Advice on Environmental Impact Statement – State Significant Development

Proposal: Wattle Creek Battery Energy Storage System

Major Project reference: SSD-63345458

Attachment A – Detailed Aboriginal cultural heritage advice for SSD-63345458

Figure 7.35 - Results of the test excavations

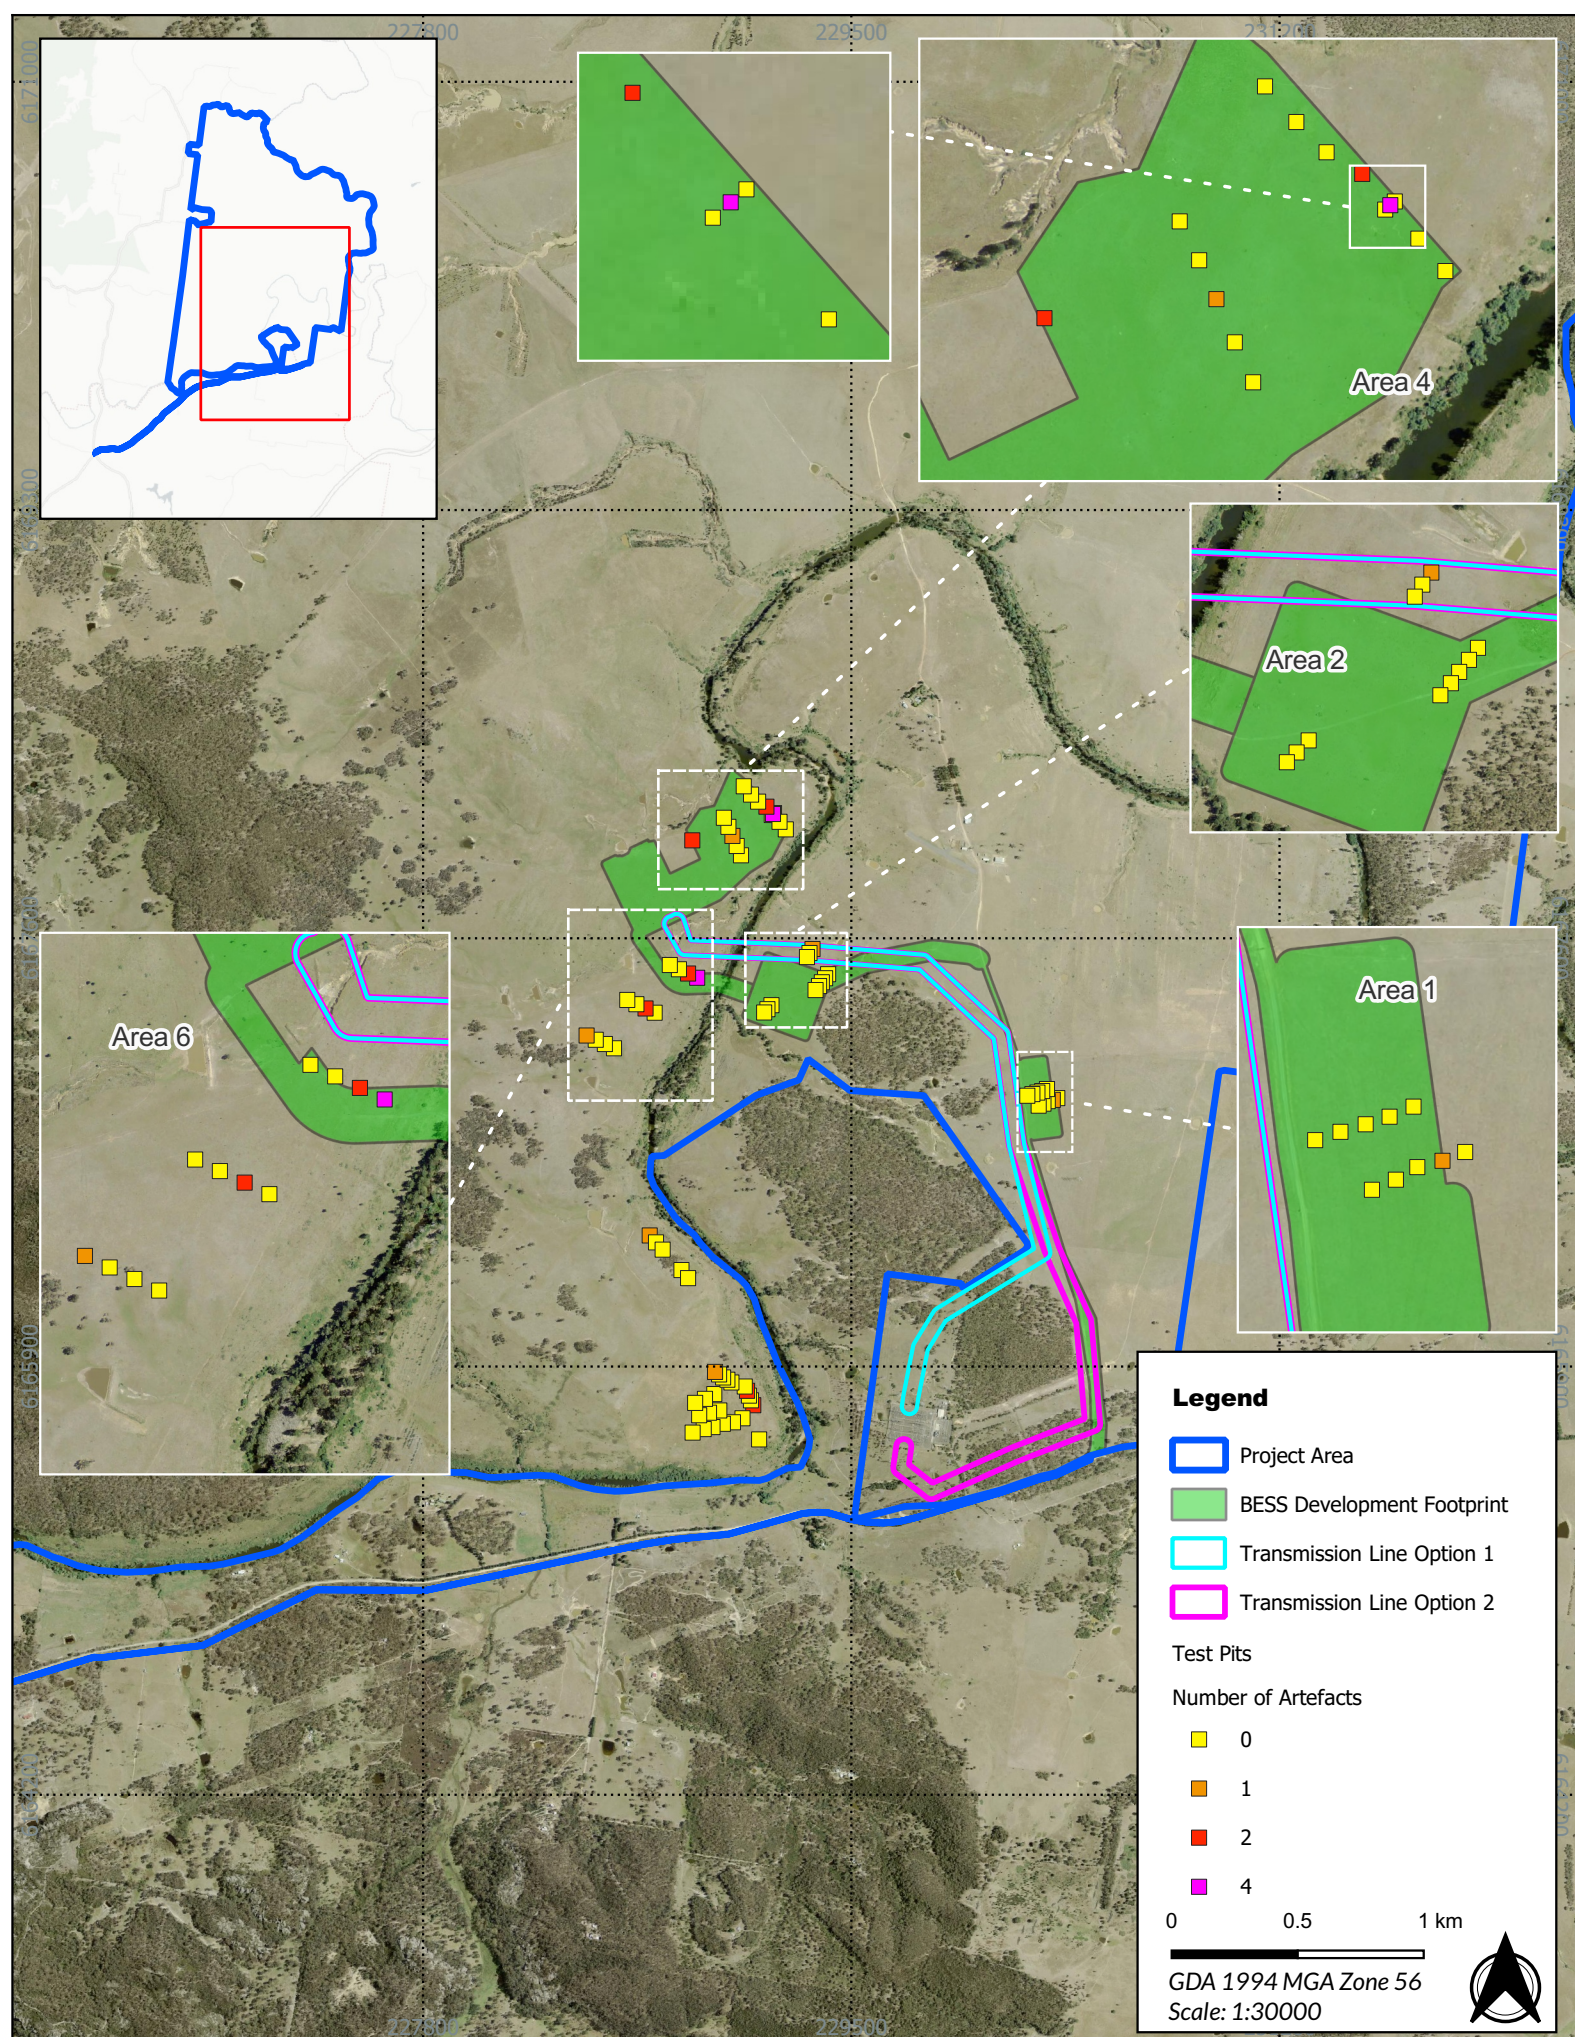
10. Figure 7.35 (Results of the test excavations) shows a number of test pits that were excavated within an area situated to the south of Area 6 and Area 2. The figure indicates that artefacts were recovered from these areas, however, these results have not been discussed in the ACHAR, and it is unclear whether these areas have been registered as Aboriginal sites on Aboriginal Heritage Information Management System (AHIMS) consistent with artefacts having been recovered. We note that, while the areas may now be outside of the proposed disturbance footprint, the results of assessment in this area must still be documented within the ACHAR consistent with the requirements for investigations undertaken under the Code of Practice. Please update the ACHAR to meet this requirement, confirm whether the area has been registered as a site on AHIMS and update the significance and impact assessments accordingly.

Figure 7.52 - Location of test pits and artefact distribution within testing area 6

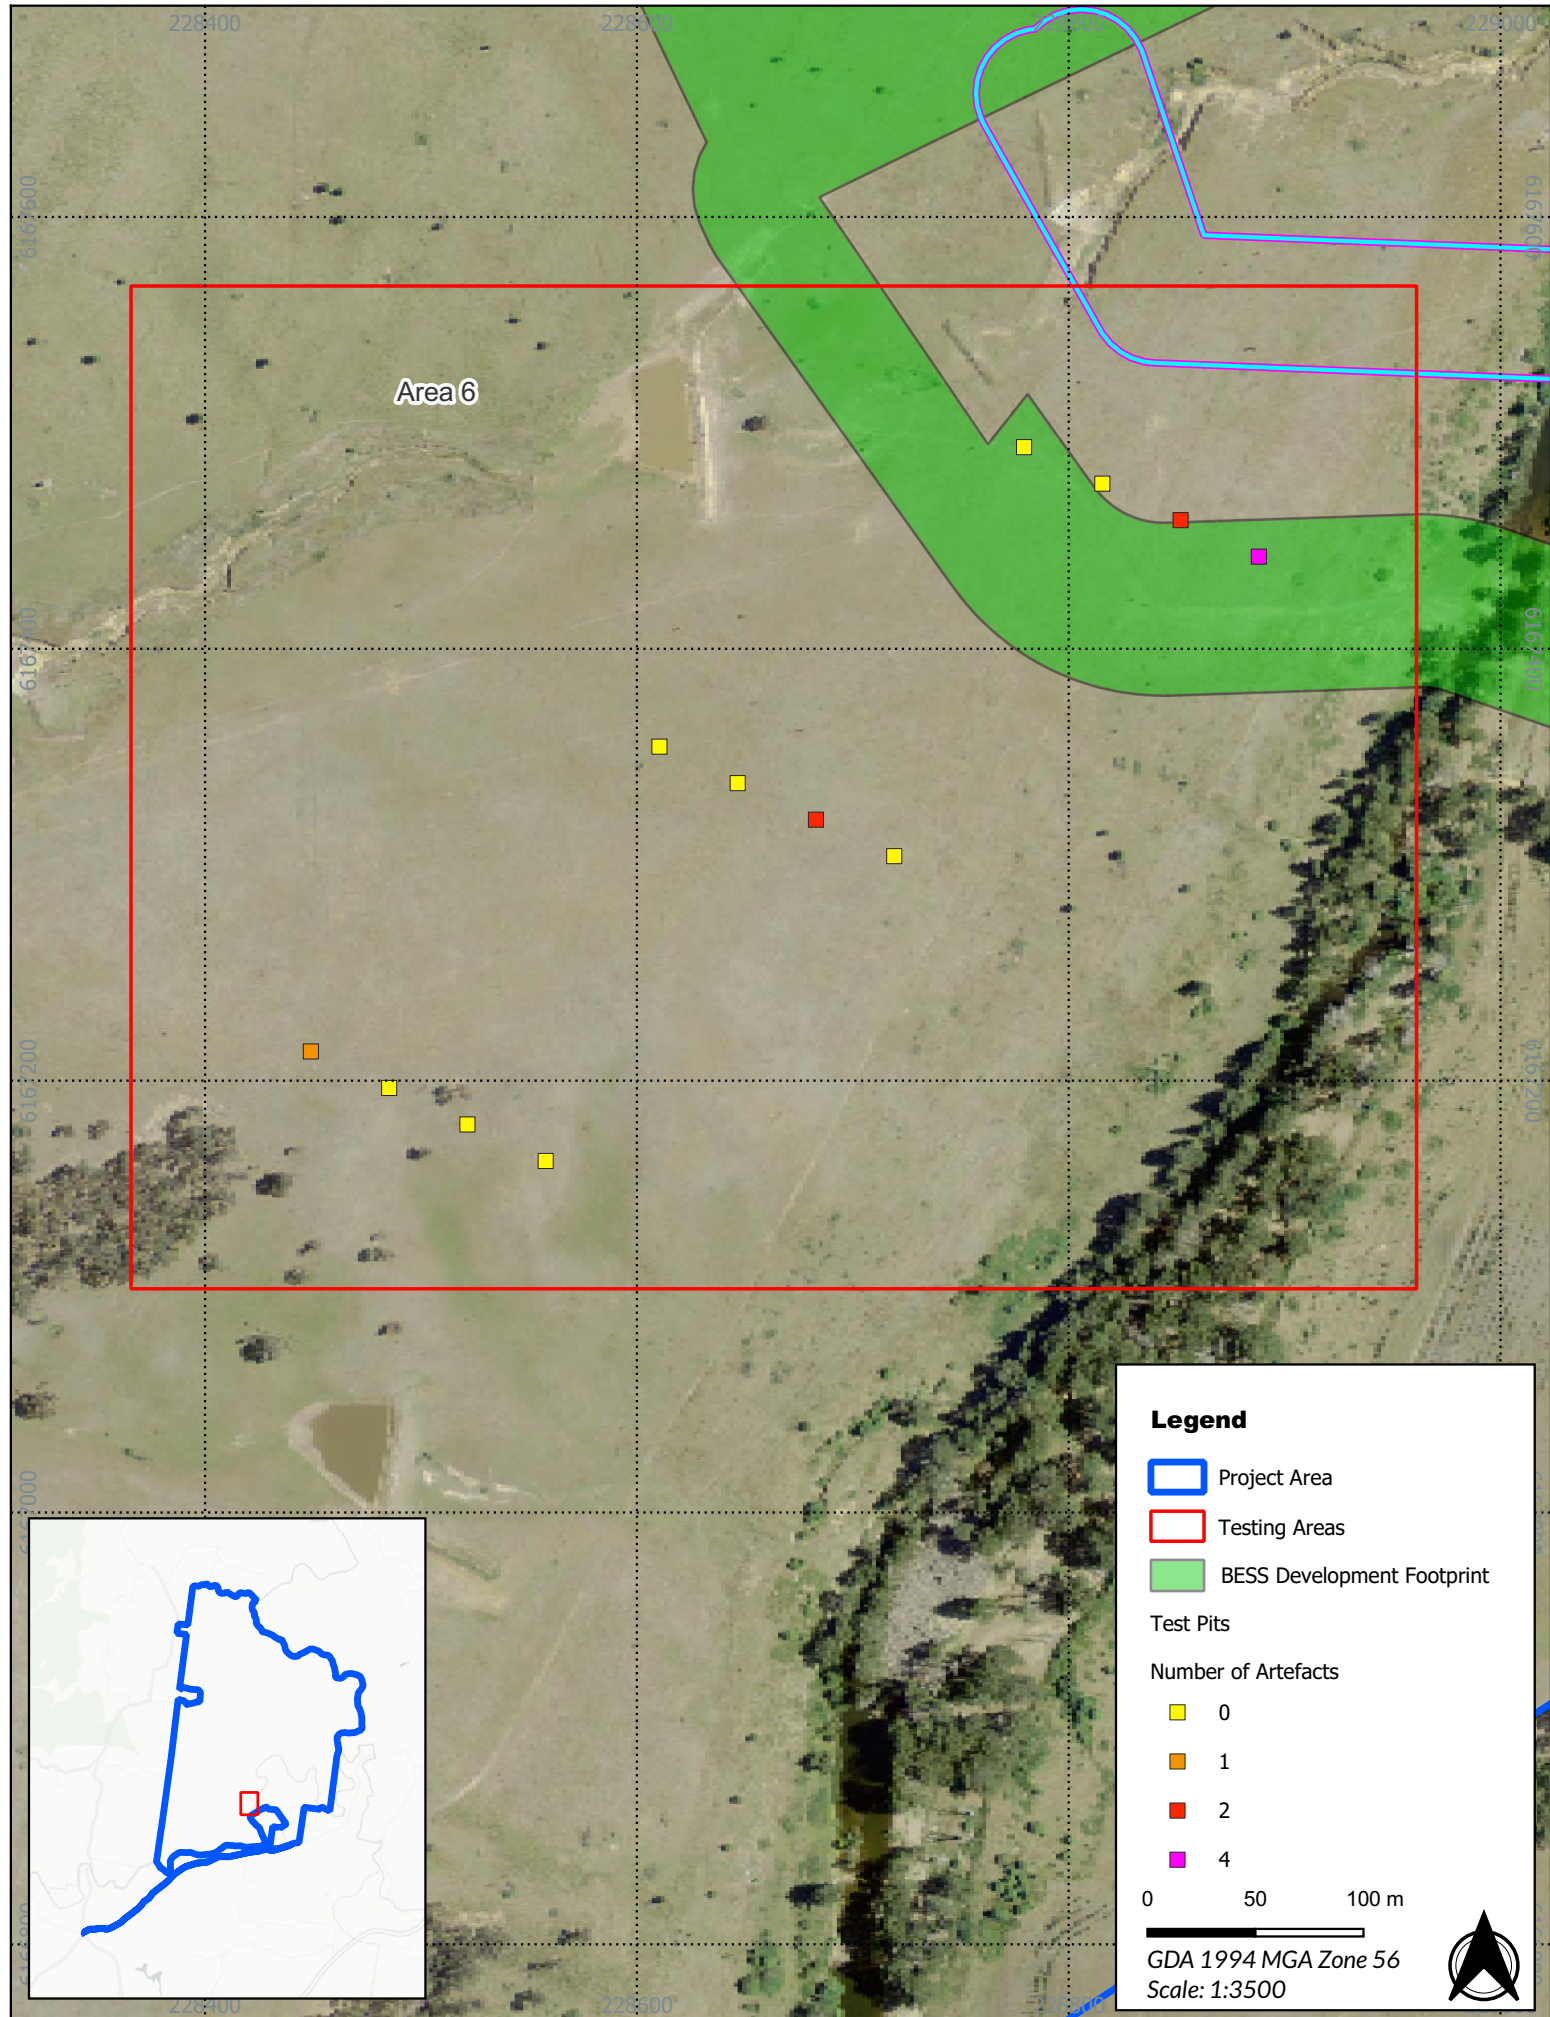
11. Figure 7.52 shows a series of eight (8) test pits that were excavated outside of the proposed BESS development corridor within 'Testing Area 6'. According to the figure three (3) sub-surface artefacts were recovered from test pits in this area. The ACHAR, however, does not include discussion of these test pits (i.e. they are not included in the 40 test pits noted as being excavated to inform the ACHAR) and it is unclear how these artefacts have been interpreted and recorded. Please clarify this discrepancy and confirm whether these artefacts are captured within the extent of any Aboriginal site/s recorded within Area 6 or whether they have been registered as a new site. As with our previous comment, the ACHAR must be updated to include these results and meet the requirements of the Code of Practice.
